Rezoning Transportation Analysis

Petition Number: 2025-091

Revision Log:

Date	Description
08-28-25	First Review (CM)
11-20-25	Second Review (CM)

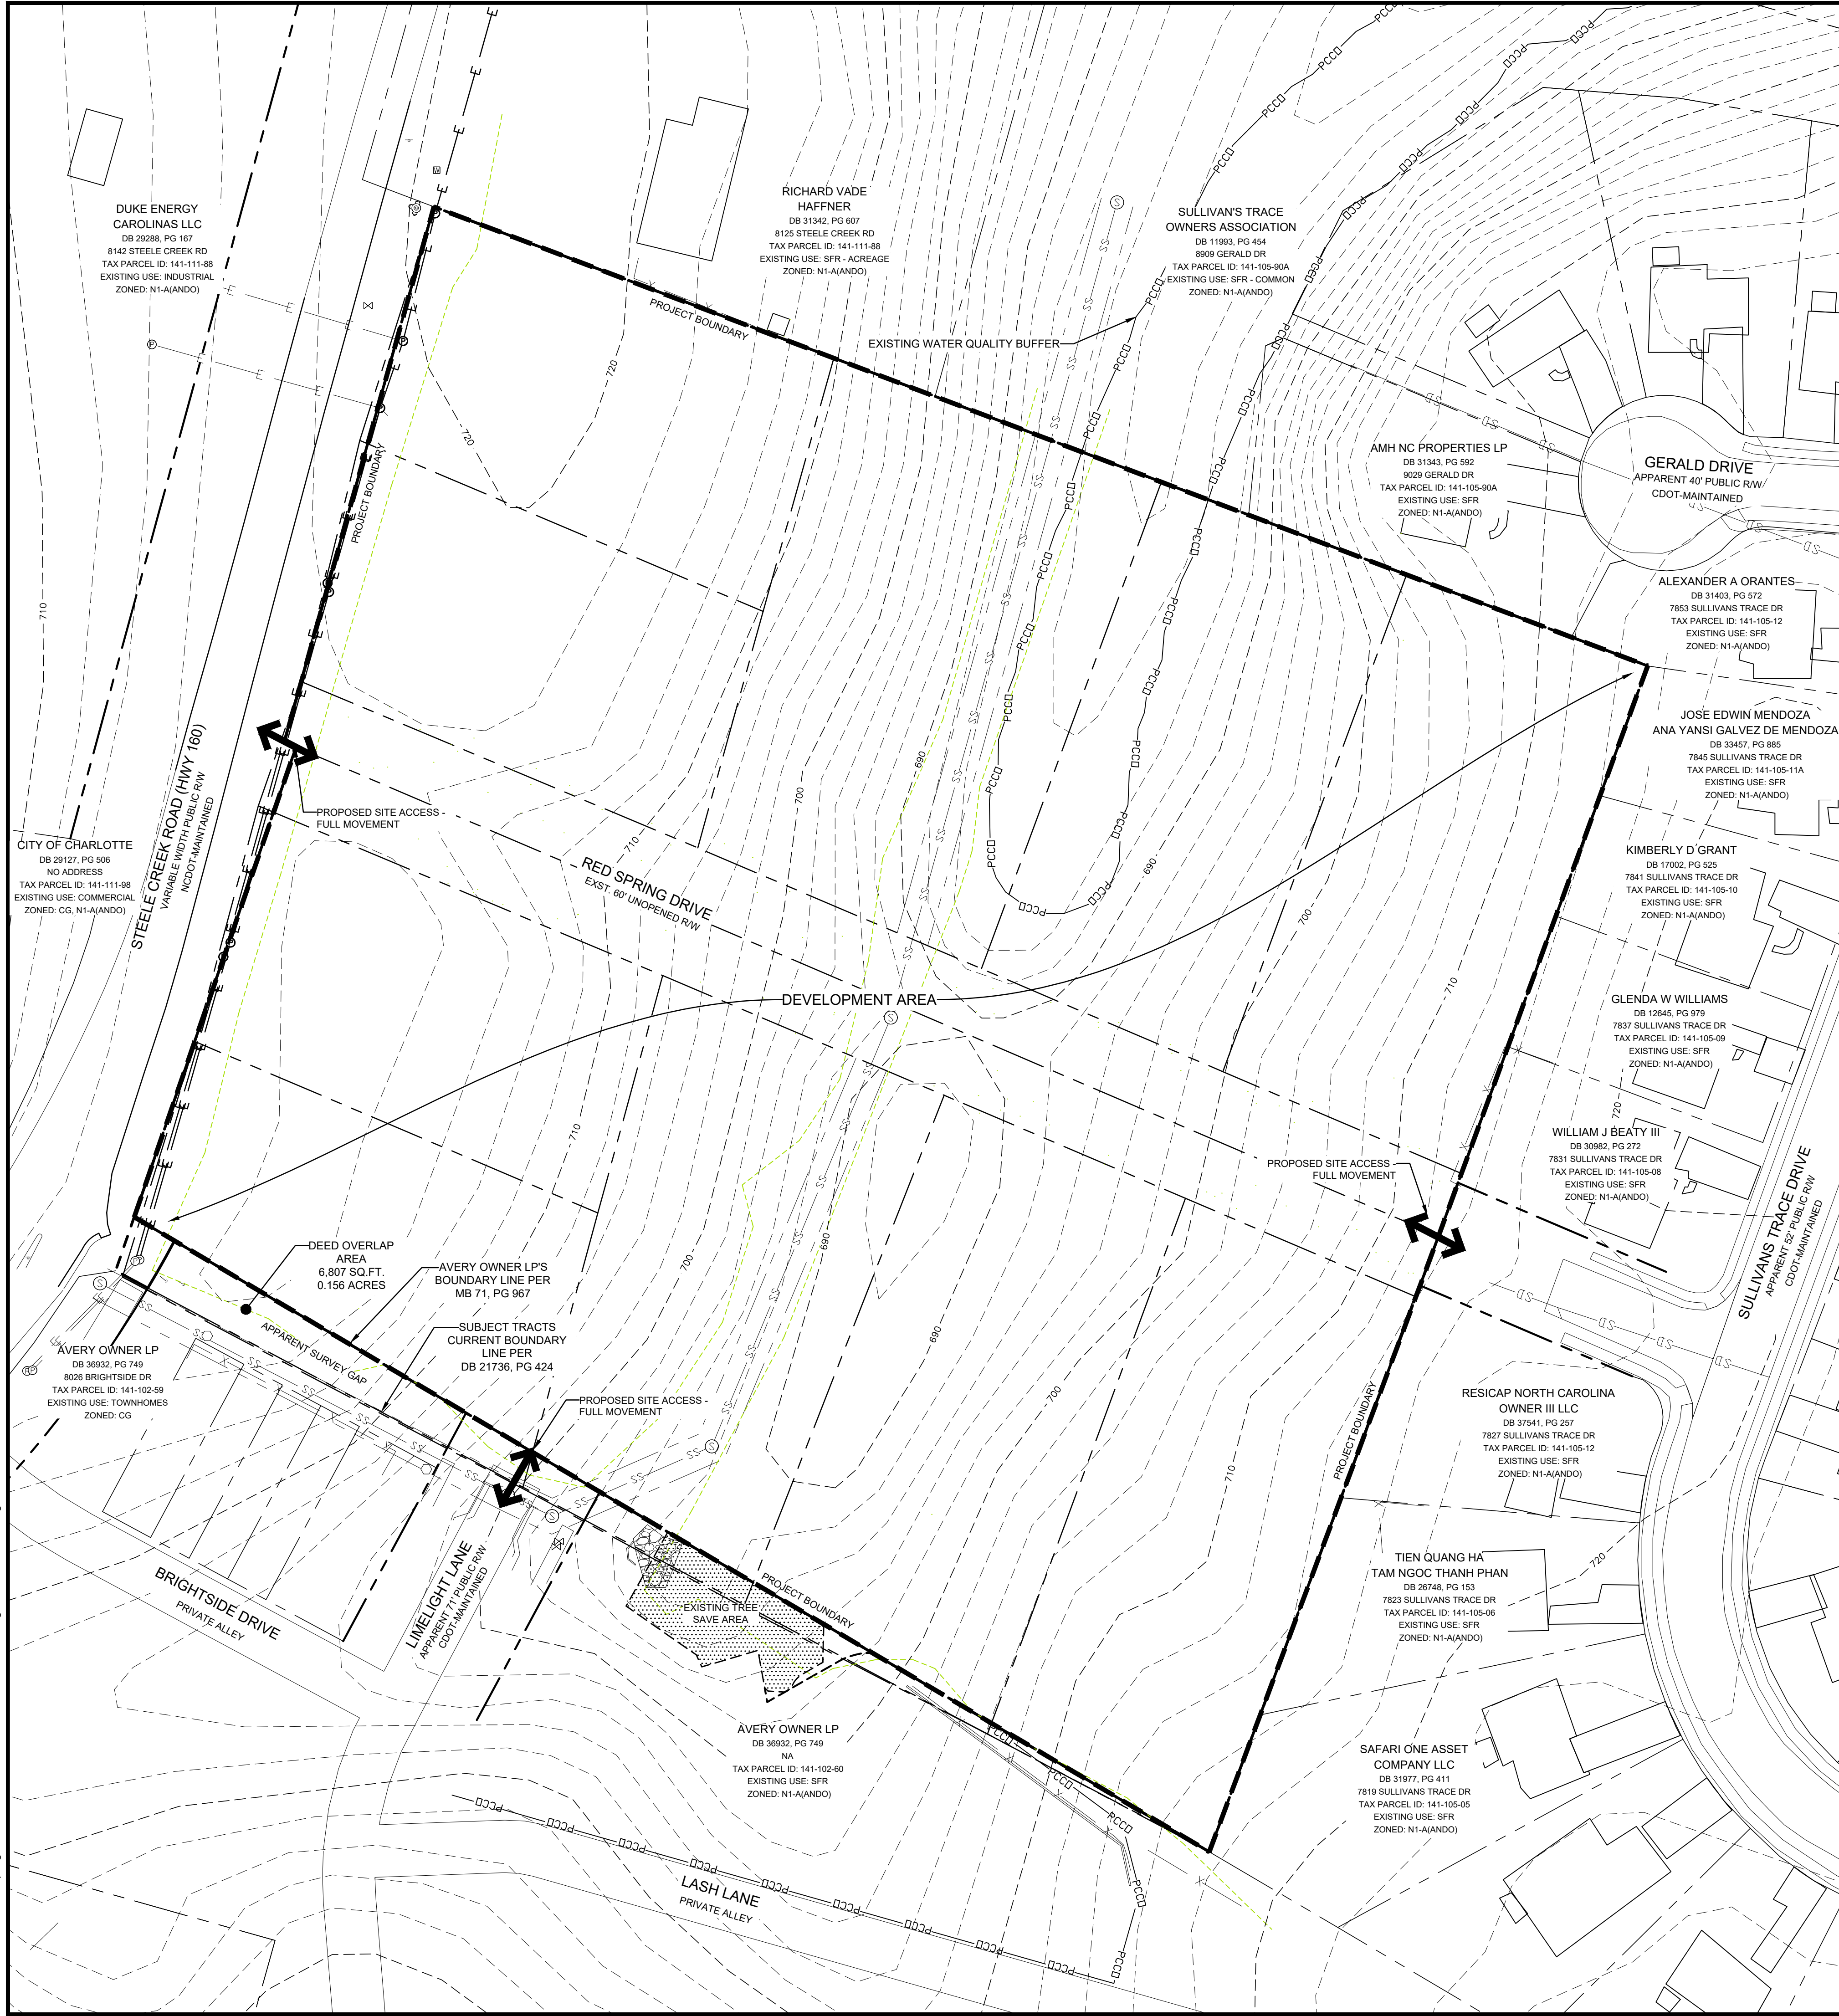
Steele Creek Road: The future location of the back of curb and gutter is minimum 38ft from roadway centerline to accommodate a 4+ Avenue, Buffered/Separated Bike Lanes per Charlotte Streets Map.

Label and dimension the curb and gutter from the centerline for each road on the site plan.

- Revise site plan and conditional note(s) to commit to dedicate minimum 54-feet right-of-way from the road centerline along Steele Creek Road. The site plan shall label and dimension the right-of-way from the road centerline.

Clarifying Comment 11/20/2025: 54-feet is minimum Right-of-way dedication along Steele Creek Road. With addition of Right Turn Lane extend right-of-way dedication to the back of sidewalk and revise dimension(s) accordingly. If ROW is placed at the back of sidewalk and not 2 feet behind the sidewalk add a 2-foot sidewalk utility easement behind the sidewalk.

Clarifying Comment 11/20/2025: If NCDOT is okay without a 100-ft protected stem provide correspondence from NCDOT to chris.manno@charlottenc.gov. If NCDOT does not have stem requirements the location of private alley #1 will still need to meet UDO requirements of 75 feet from an unsignalized intersection. Distance is measured from Point of Curvature (PC) of driveway to PC of intersection.

12. **New Comment 11/20/2025:** Add 10x10 sight visibility triangle to driveway along Limelight Lane and Private Alley #3.
13. **New Comment 11/20/2025:** Ensure all on-street parking zones are a minimum of 20-ft (tangent) from the Point of Curvature of the driveway (Typical throughout the site plan).

14. **New Comment 11/20/2025:** Show a minimum 2ft ROW or SUE behind sidewalk throughout the site. Make sure no structures or seating areas are located within the Right-of-way or Sidewalk Utility Easement (SUE).

15. **New Comment 11/20/2025:** Revise site plan to eliminate conflict within 10x10 sight triangle. Car parked in driveway is in 10x10 sight triangle for first lot along private alley #1.

16. **New Comment 11/20/2025:** Align Red Spring Drive with existing roadway (centered along ex. Centerline) and avoid the kinked alignment.
